**RE: Presbyterian Hospital Expansion
1100 Central SE et al.
Conceptual Grading and Drainage Plan
Engineer's Stamp Date: 10/3/19
Hydrology File: K15D005**

Based on the submittal received on 10/3/19, the Grading and Drainage Plan cannot be approved until the following corrections are made:

DRAWING NAME CONCEPTUAL **GRADING AND**

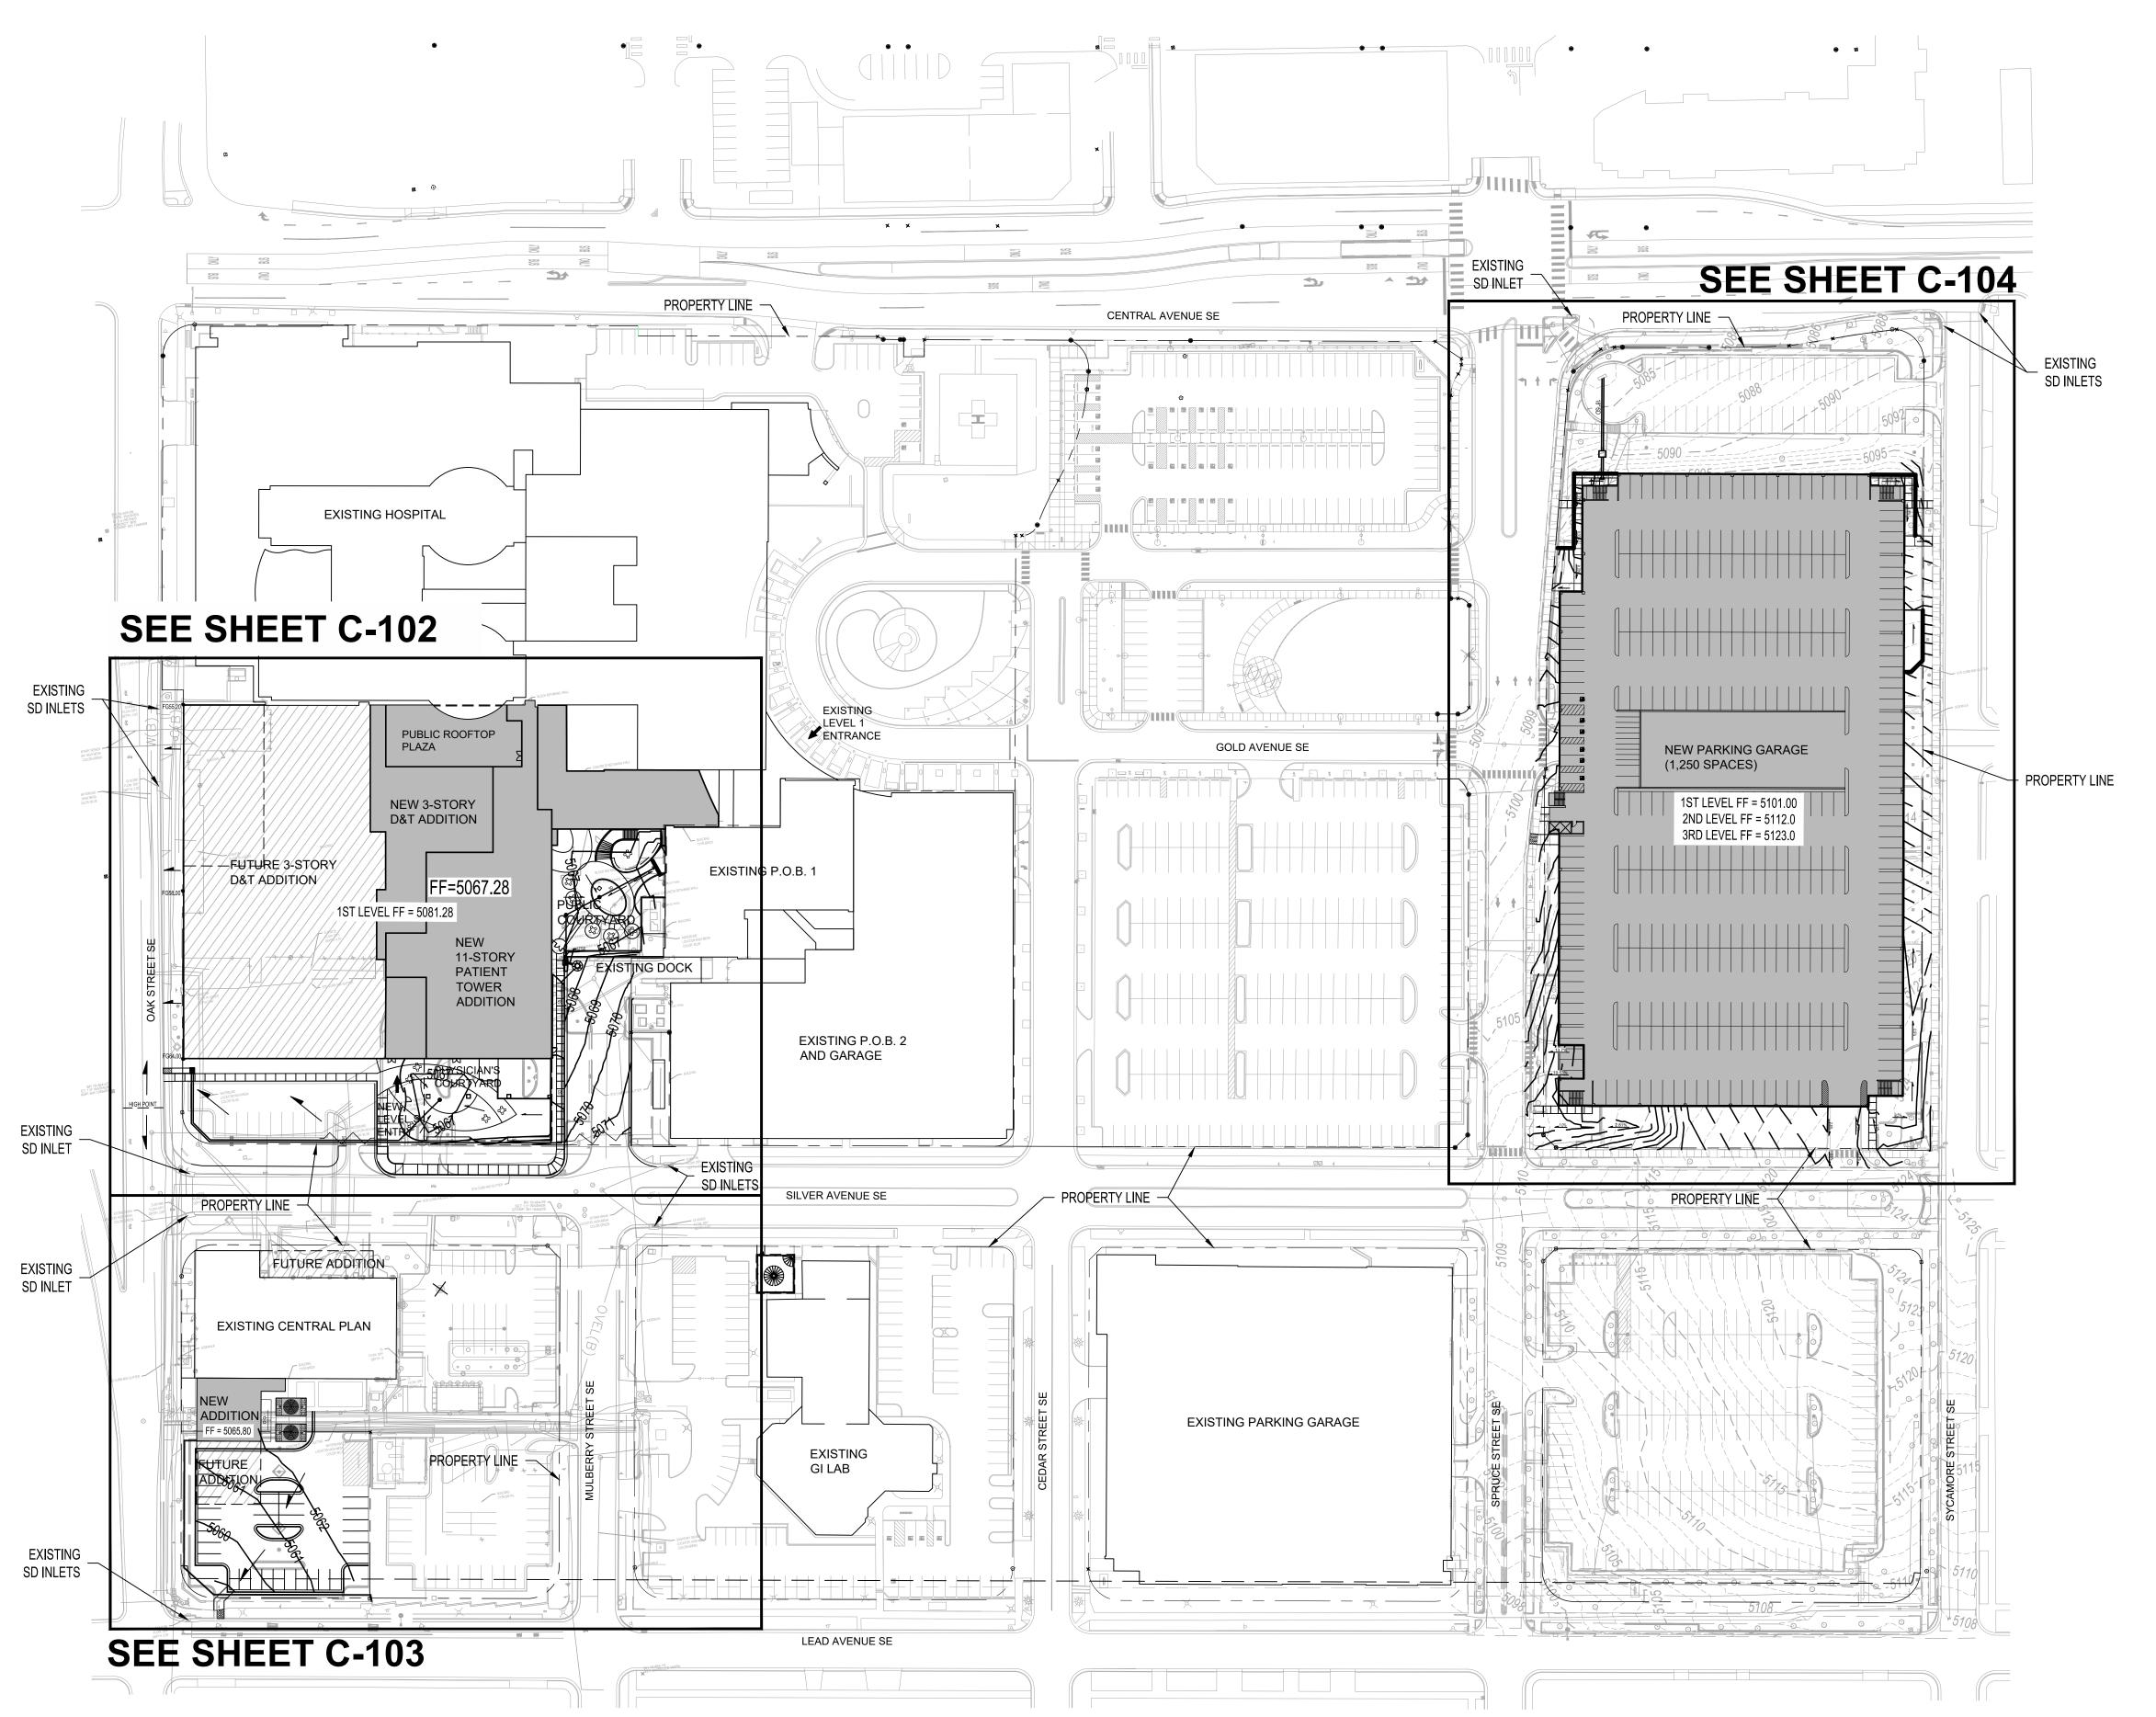
1. The grading plan needs to cover the full extent of the work. The north edge of the Patient Tower area is clipped. It may be easier just to make the Patient Tower area a separate viewport from the Energy Plant.

4. Provide existing contours, showing how the proposed grading will tie-in at property line. This is provided on the parking garage viewport, but not the other two areas.
